Ann Machado - 81 Brighton Ave. - Permit #2013-02572

From: Ann Machado
To: phillip.j.davis71@gmail.com
Date: 12/9/2013 8:12 AM
Subject: 81 Brighton Ave. - Permit #2013-02572

1/4" = 1'-0"

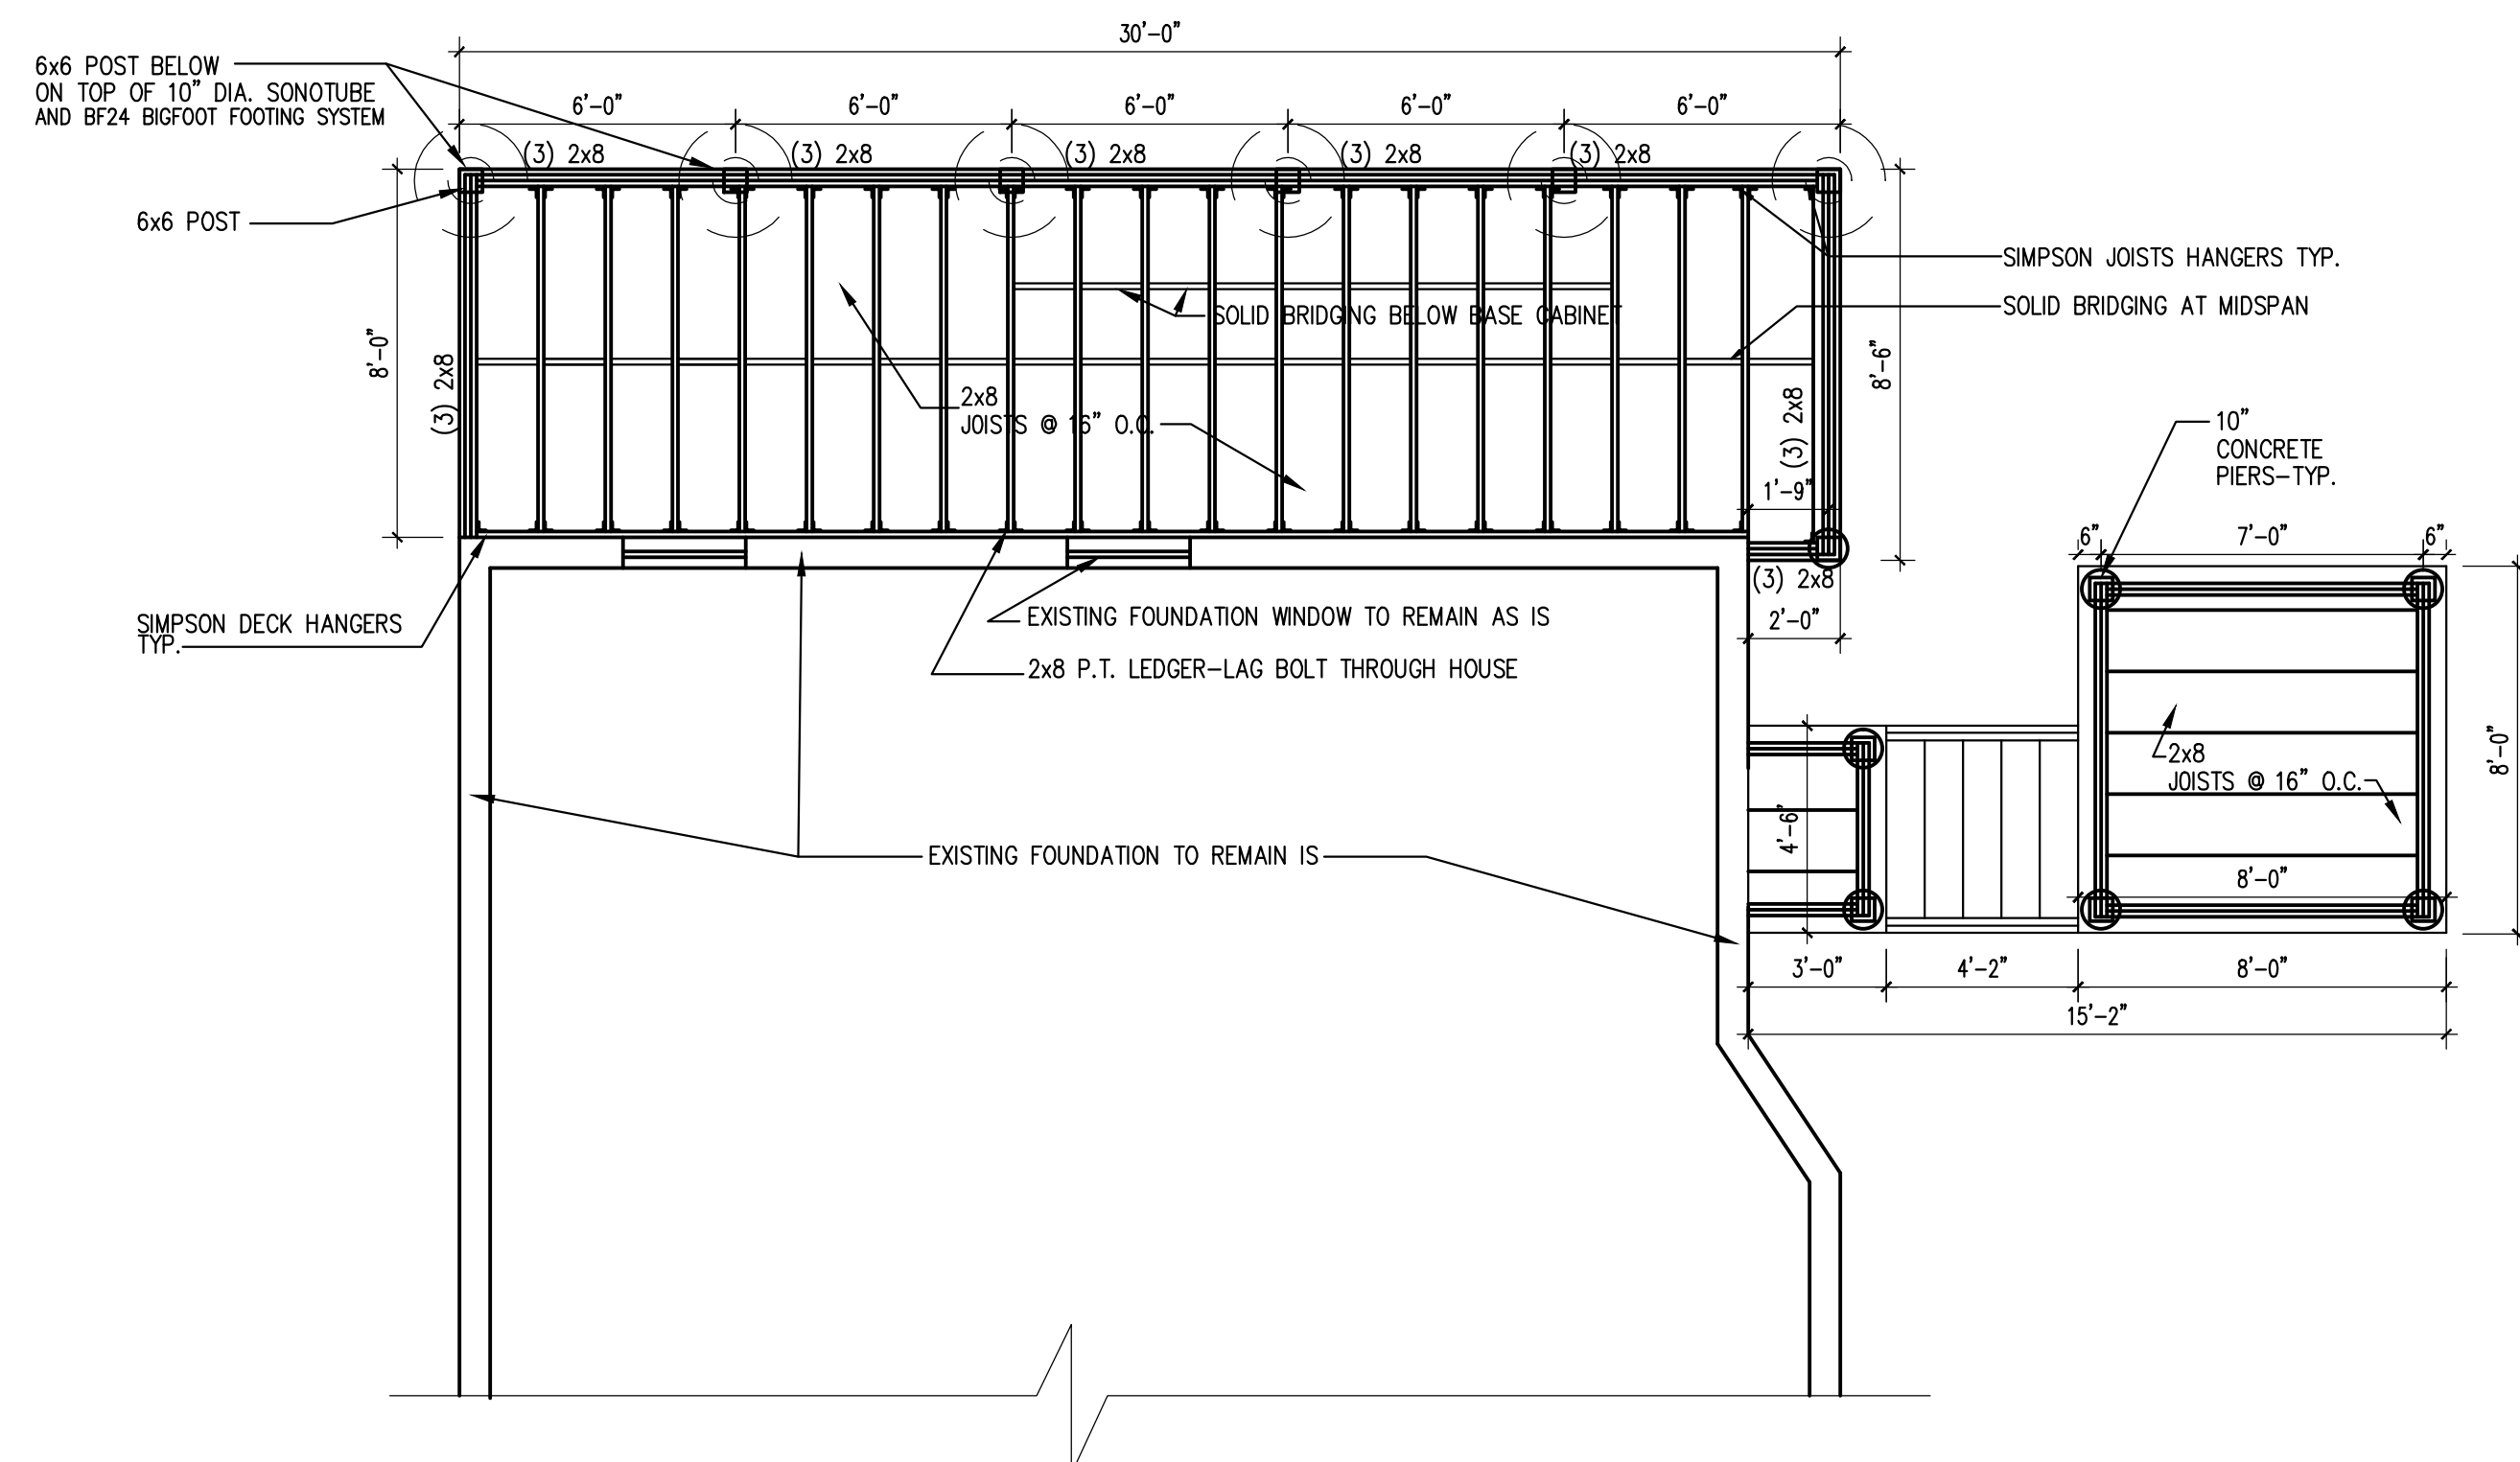
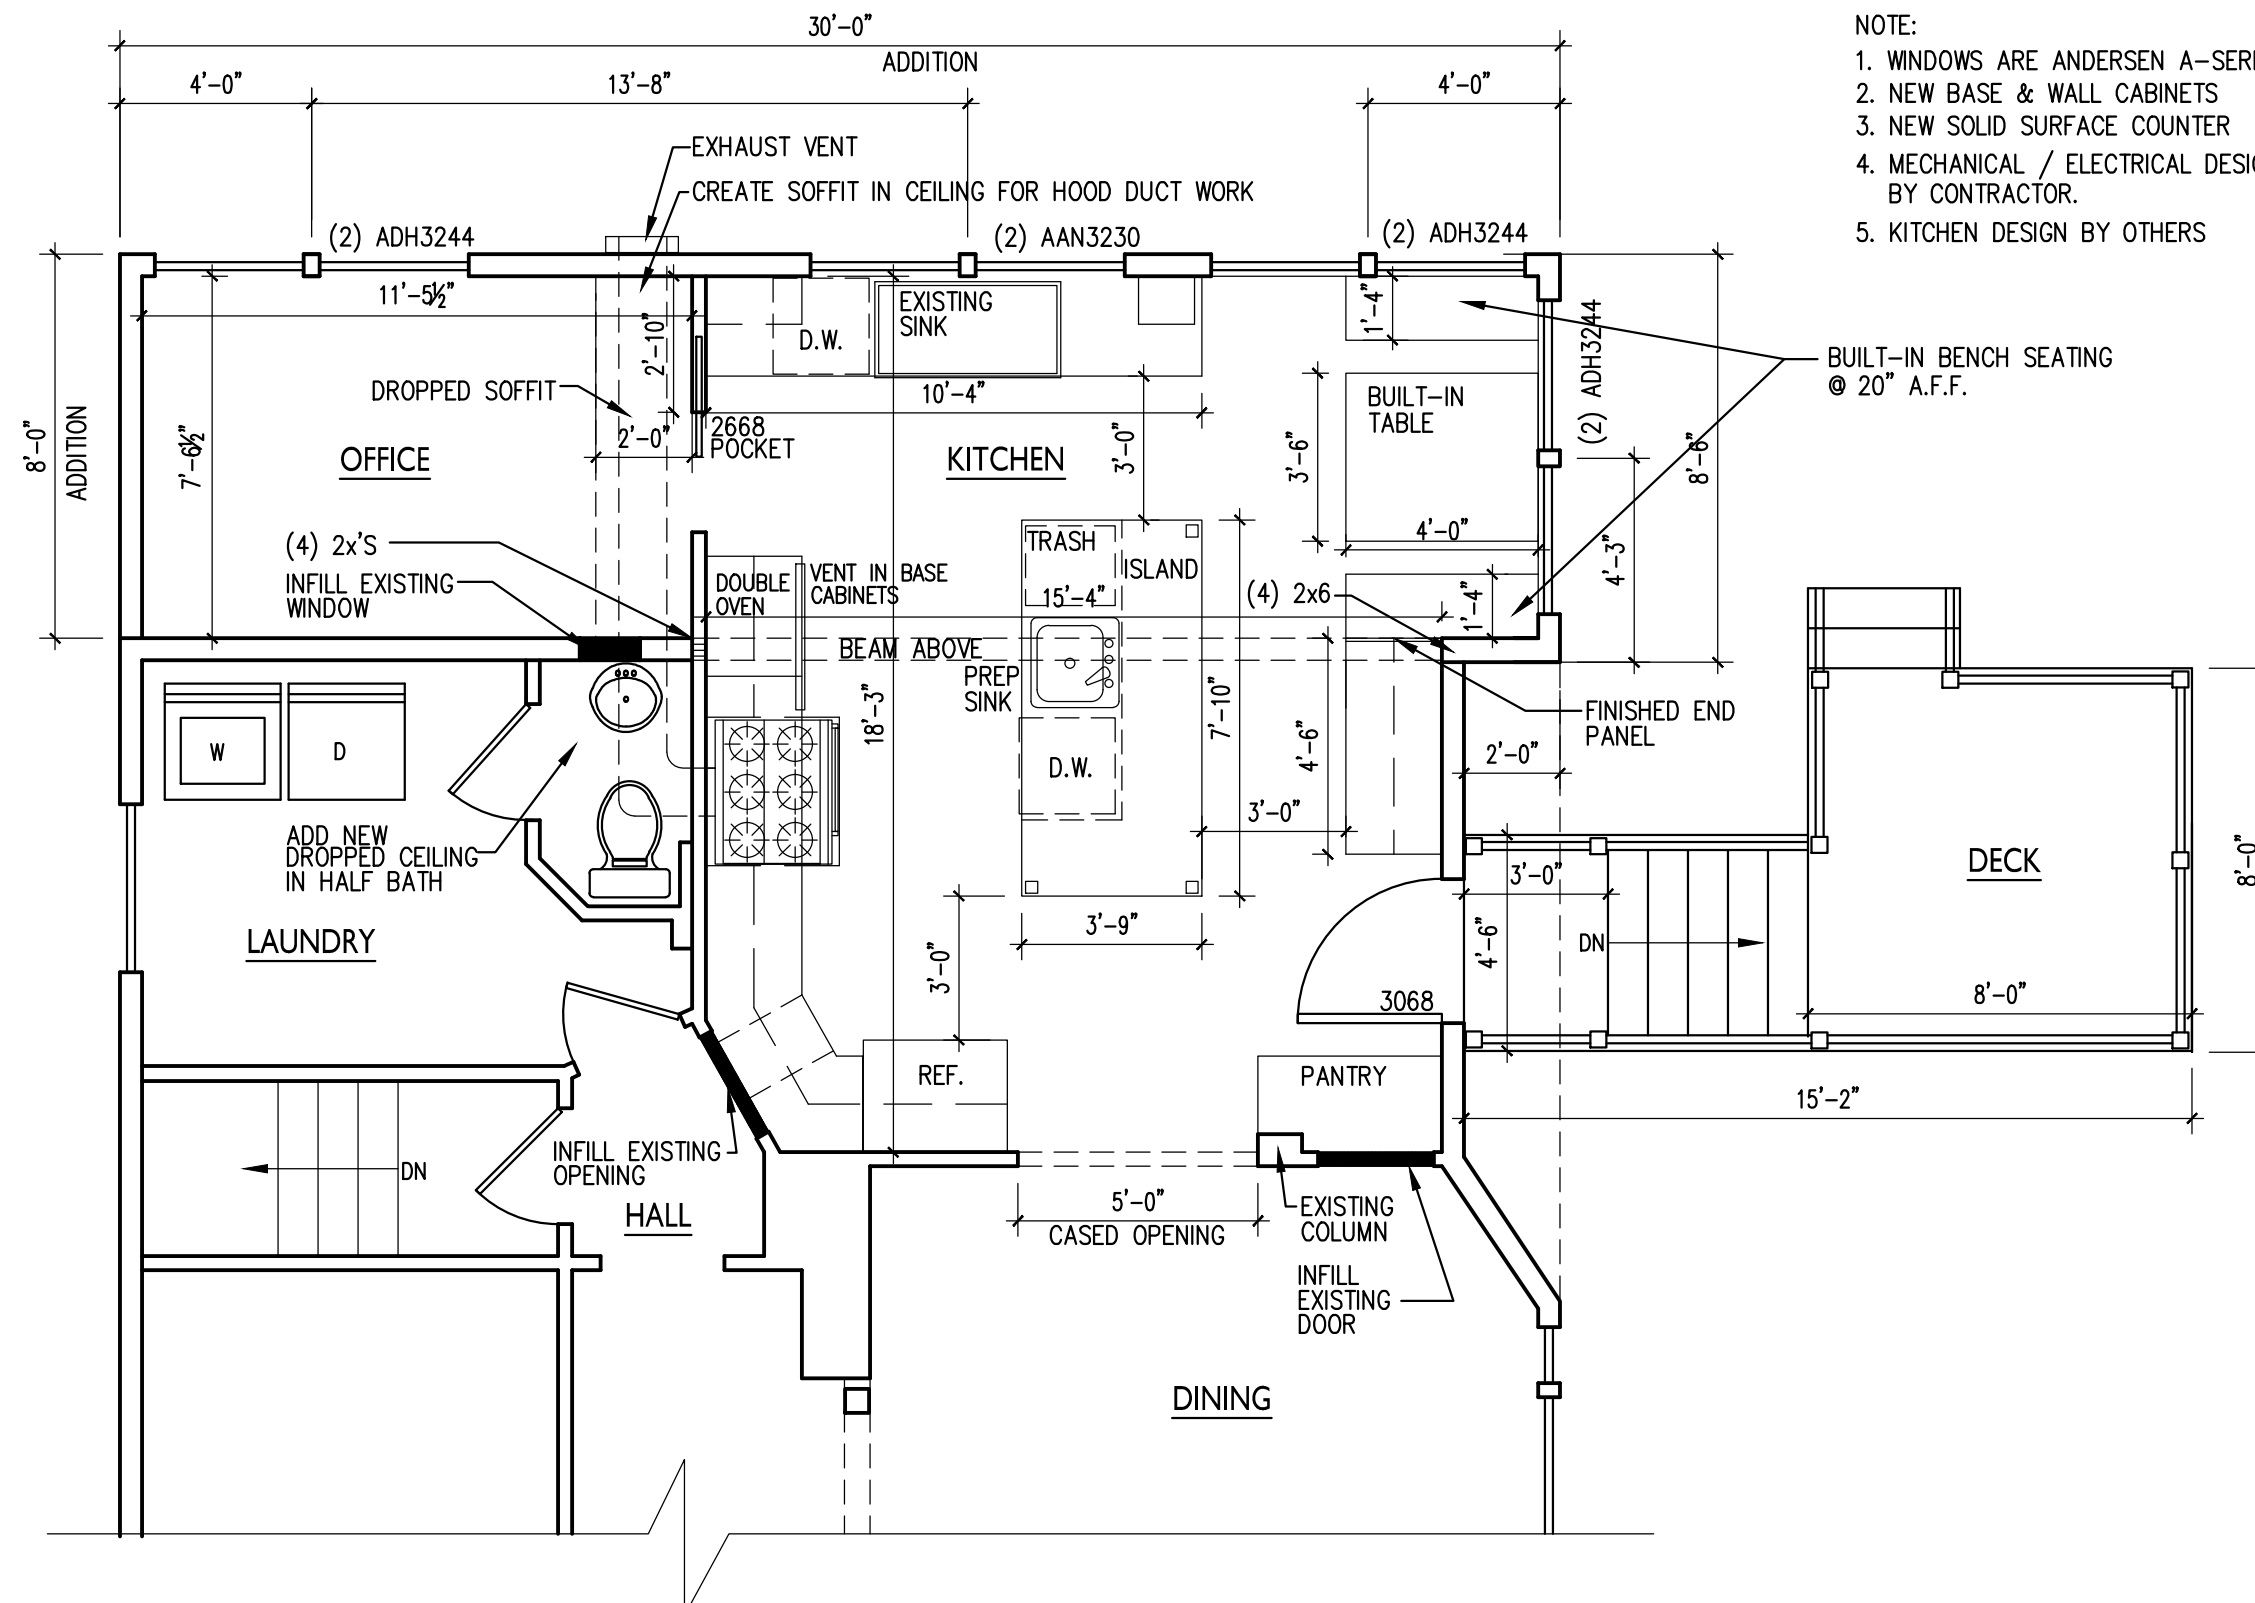
Also, now that we are doing electronic plan review, each plan needs to include a graphic or bar scale. We have to be able to calibrate our measuring tool when doing our review.
